Our Ref: P/98/14/PL

**Town & Country Planning Act 1990 (as amended)
Town and Country Planning (Development Management Procedure) (England) Order 2010 (as amended)
Application for Planning Permission**

Development Convert part of north garden curtilage into a car parking space.
Location 20 Oaktree Close Mill Farm Park Pagham

PARK HOME NO. 20. PLAN A

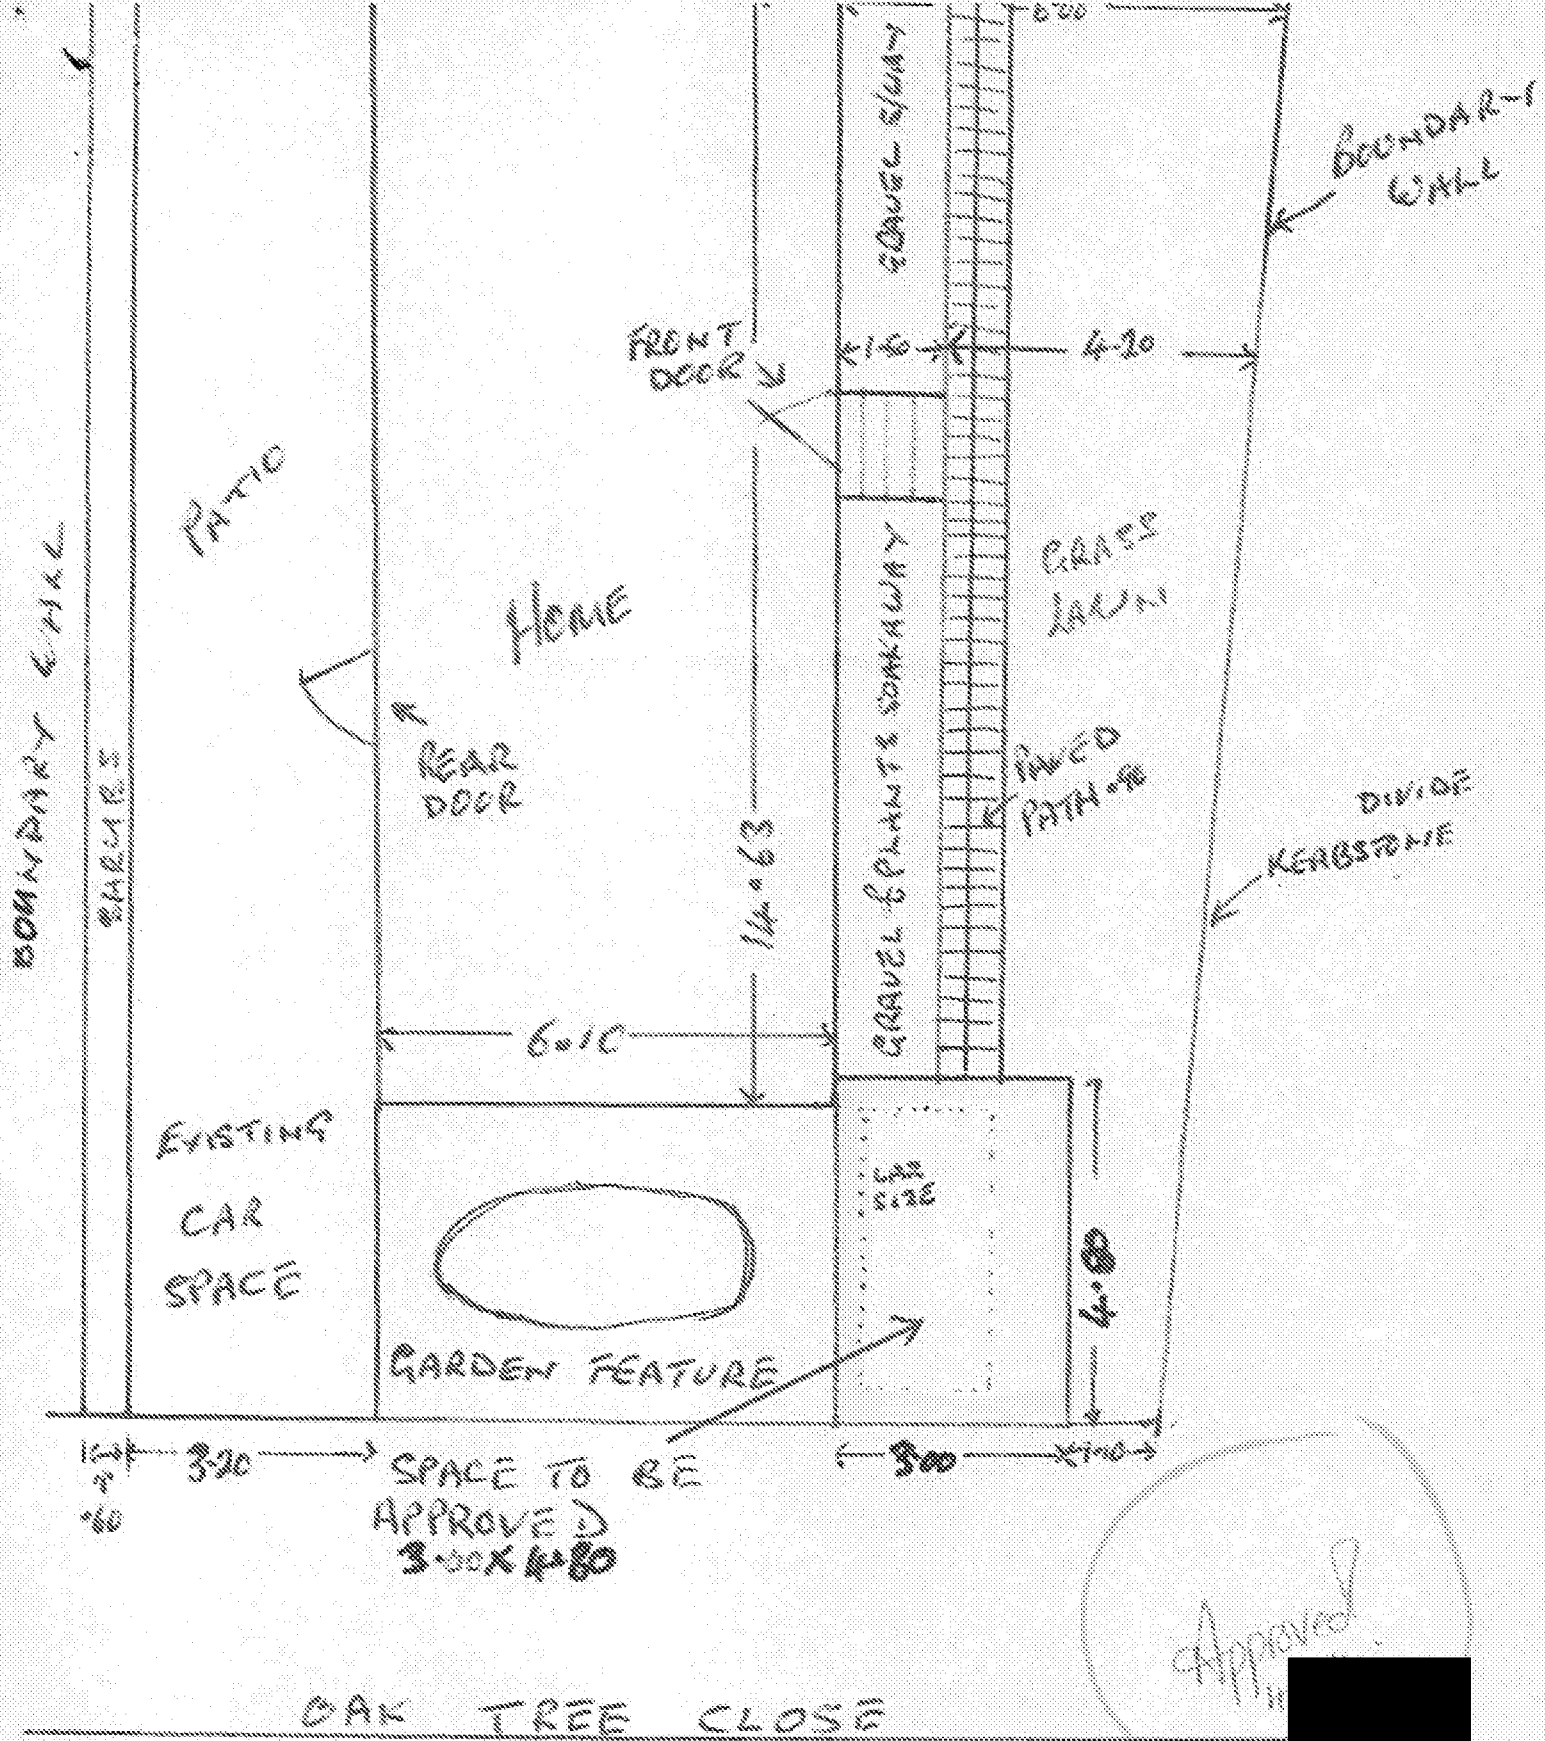
Location Plan

Your Location plan is not to scale. Please submit 1 electronic or 3 paper copies of an amended location plan at a scale of 1:1250 with the site edged in red. Further details of what must be included on the plan can be found in the National Validation Requirements.

Block Plan

Your Block plan is not to scale. Please submit 1 electronic or 3 paper copies of a block plan at a scale of 1:500 with the proposals clearly indicated/hatched on the plan. Further details of what must be included on the plan can be found in the National Validation Requirements.
